Planning Inspectorate (the Drovers Solar
Farm)

Reference: OR-0009338/01
Customer reference: EN0110013

**Deadline 3 submissions response letter
The Drovers Solar Farm**

DRAWING TITLE:
Figure 12.15: Work No. 4 Maximum Potential Foundations and Groundwater Elevations

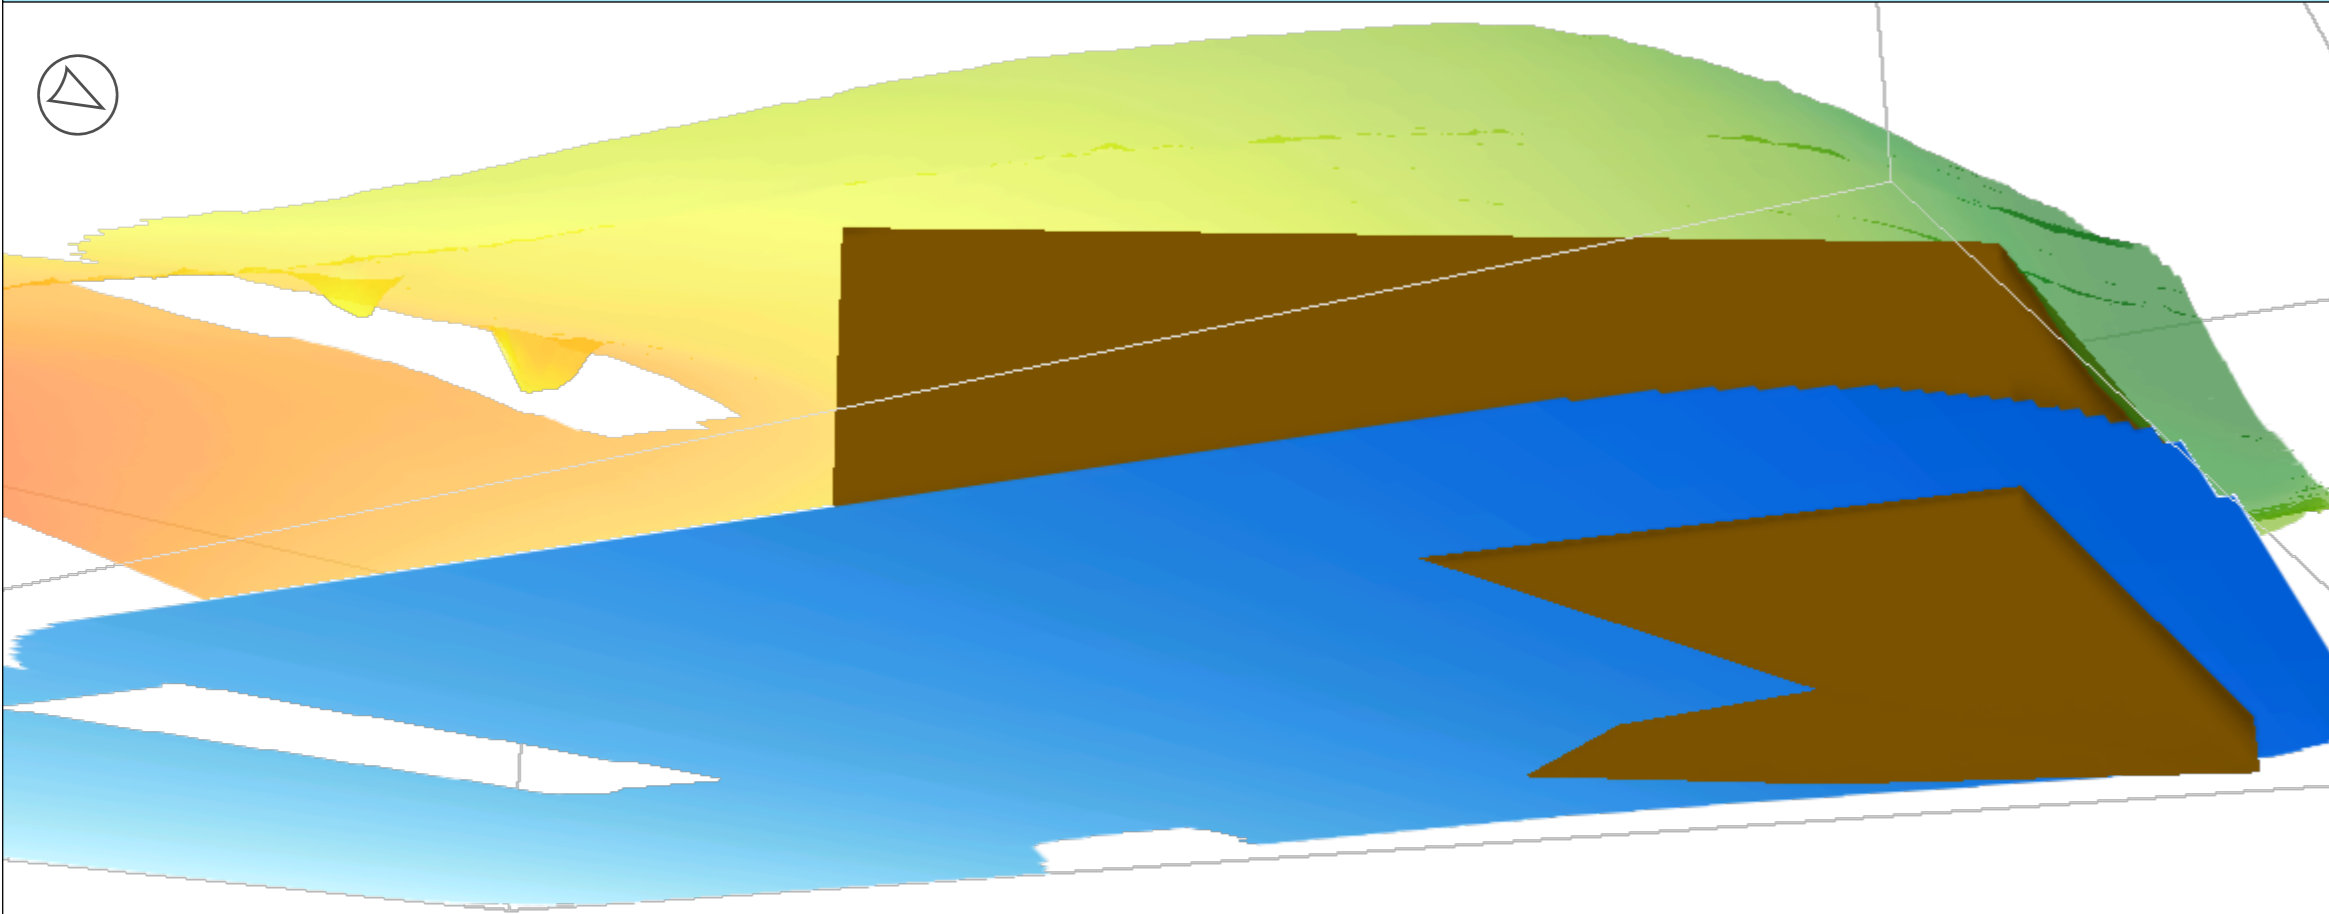
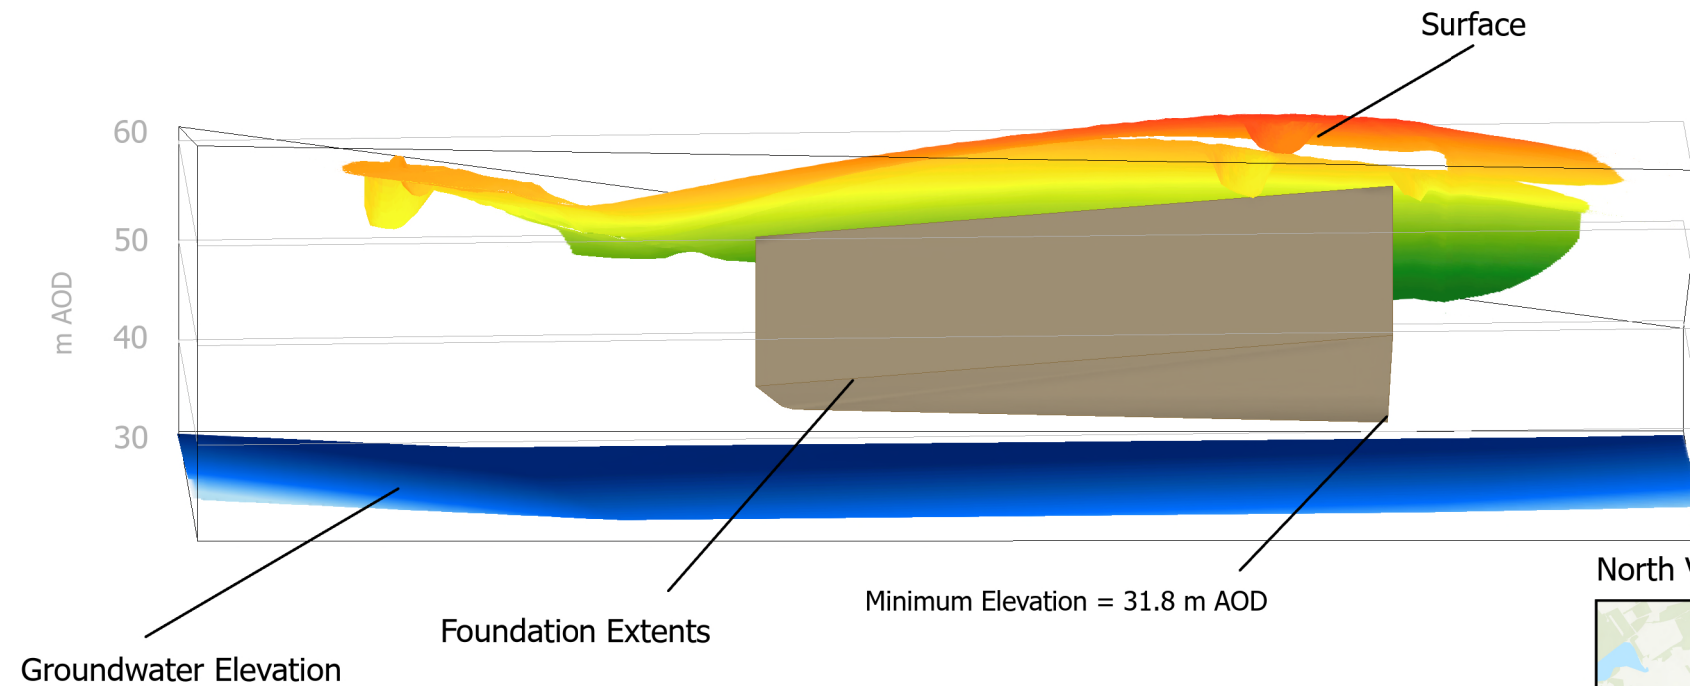
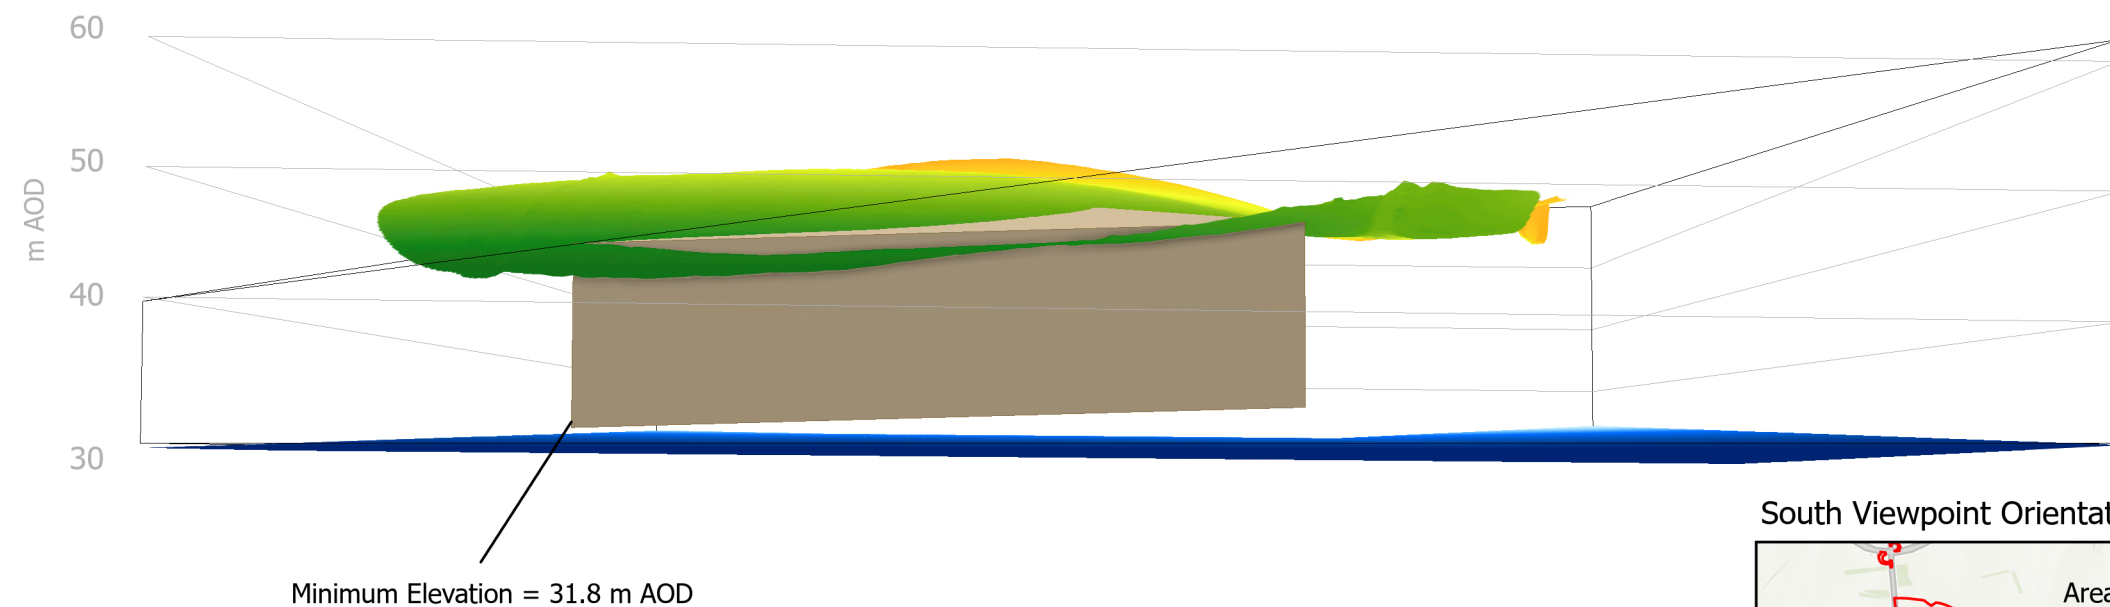
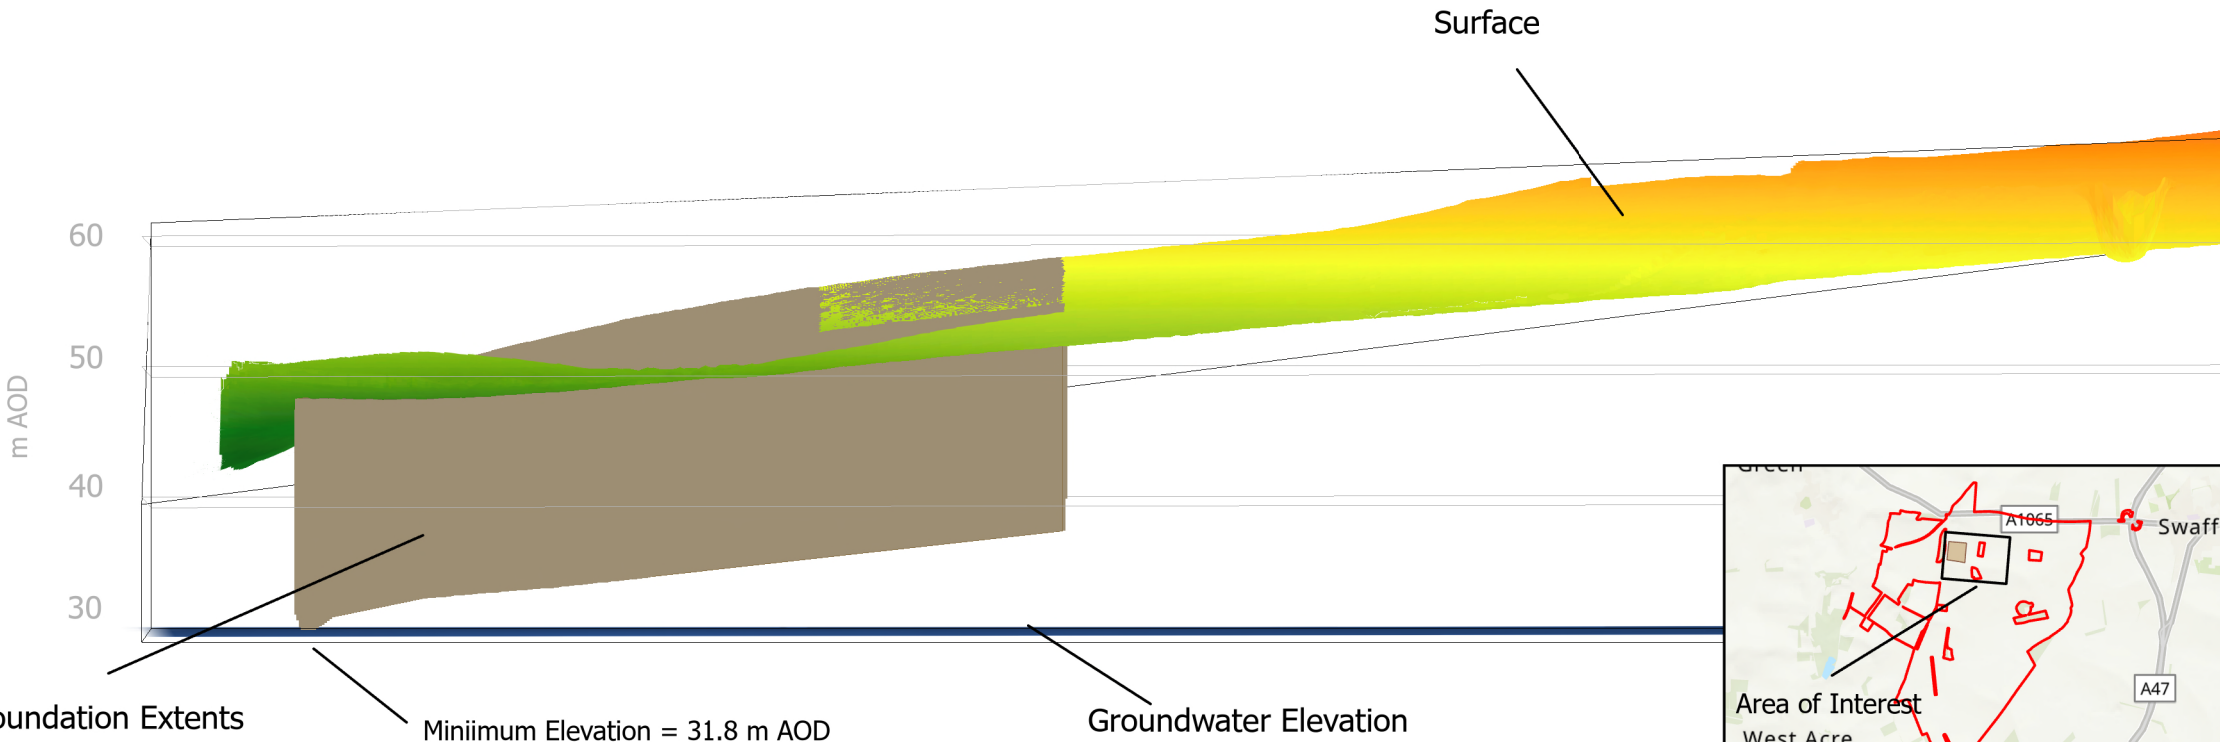
We were concerned that figures 12.13 [[APP-127](#)], 12.14 [[APP-128](#)], 12.15 [[APP-129](#)] and 12.16 [[APP-130](#)] do not clearly define the area represented by the drawings, including view orientation, or the elevation values.

- 6.3.1 ES Figure 12.15 Work No. 4 Maximum Potential Foundations and Groundwater Elevation [[REP3-045](#)]

We find the updated figures satisfactory for defining the 3D model view, and elevation the maximum extent of the foundations.

DRAWING TITLE:
Figure 12.7: Triangulated Baseline Groundwater Elevation

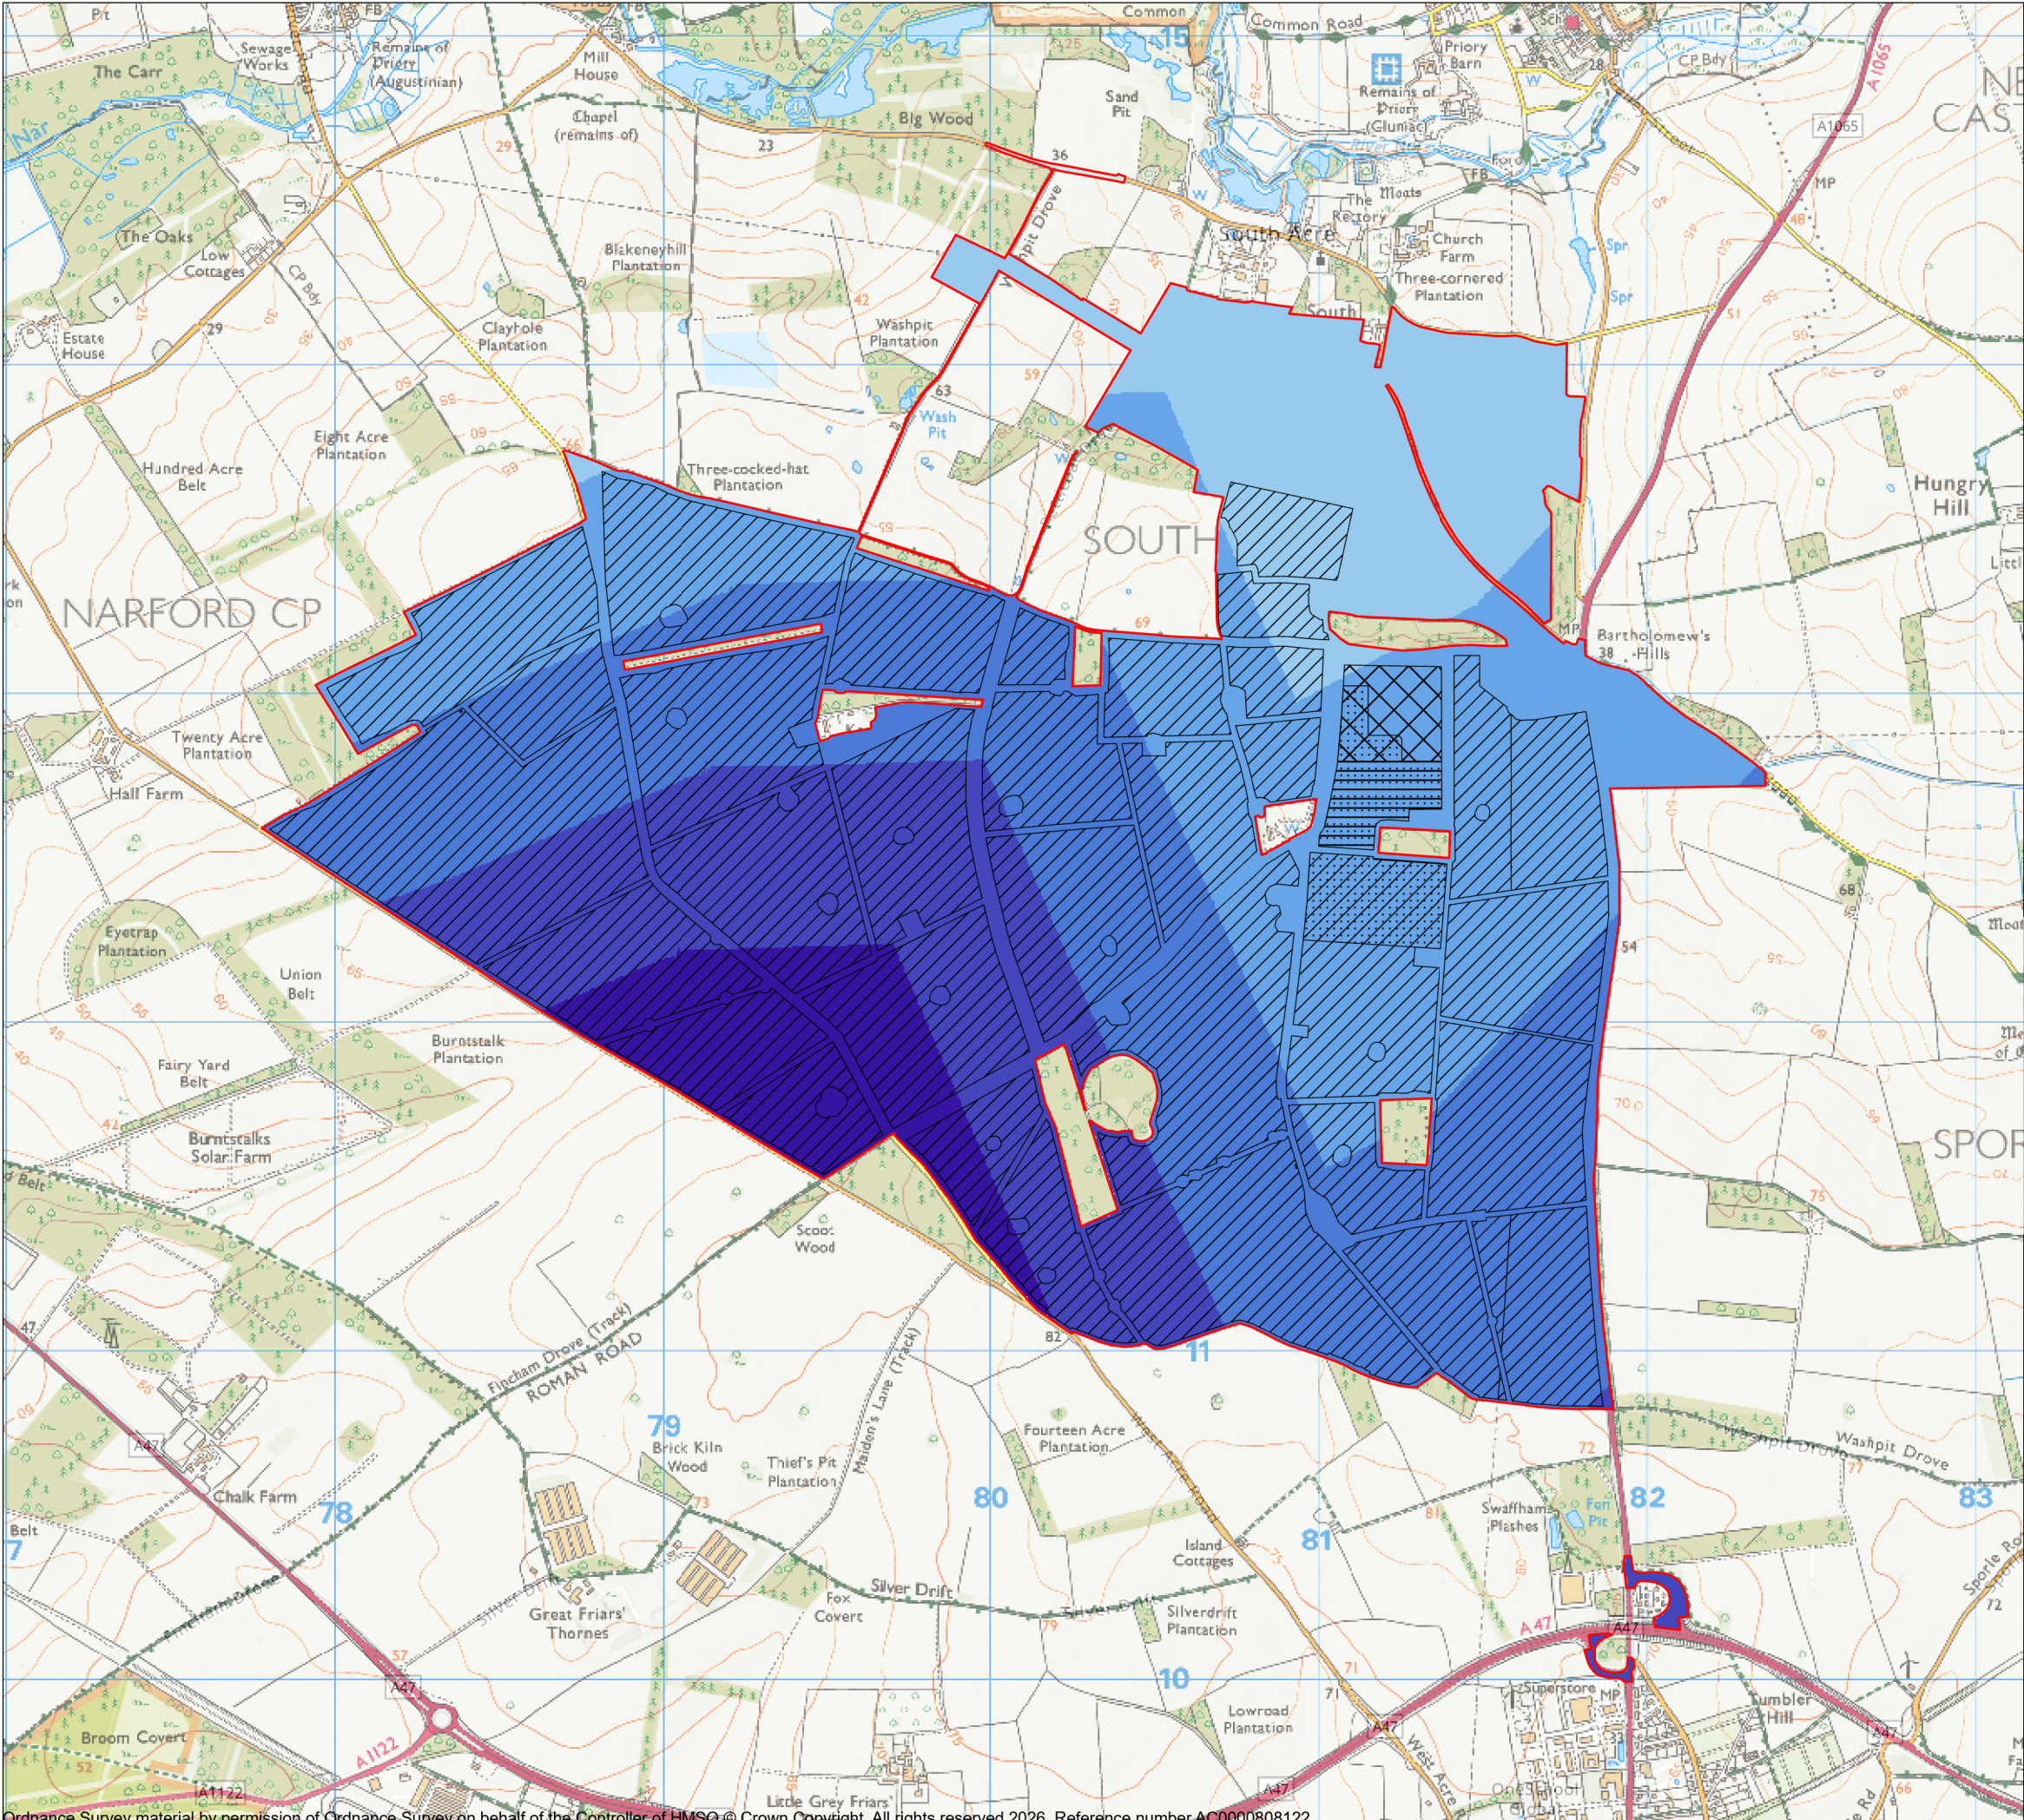
We were concerned that 6.3 Environmental Statement Figure 12.7 3D Representation of Groundwater [\[APP-121\]](#) is difficult to interpret, which limits its value. We requested additional views of the modelled area, with a clearer indication of view orientation and contouring of the groundwater surface, if applicable.

The baseline groundwater elevations are subdivided into 6 ranges in the key but only 5 categories are visible in the figure - looks like the 45.001-50 category is the one not represented visually.

- 6.3.1 ES Figure 12.7 Triangulated Baseline Groundwater Elevation [[REP3-048](#)]
- 6.3.1 ES Figure 12.8 Depth to Triangulated Baseline Groundwater Elevation [[REP3-049](#)]
- 6.3.1 ES Figure 12.9 Depth to NEAC Groundwater Wet Conditions [[REP3-050](#)]

We are content to resolve this issue.
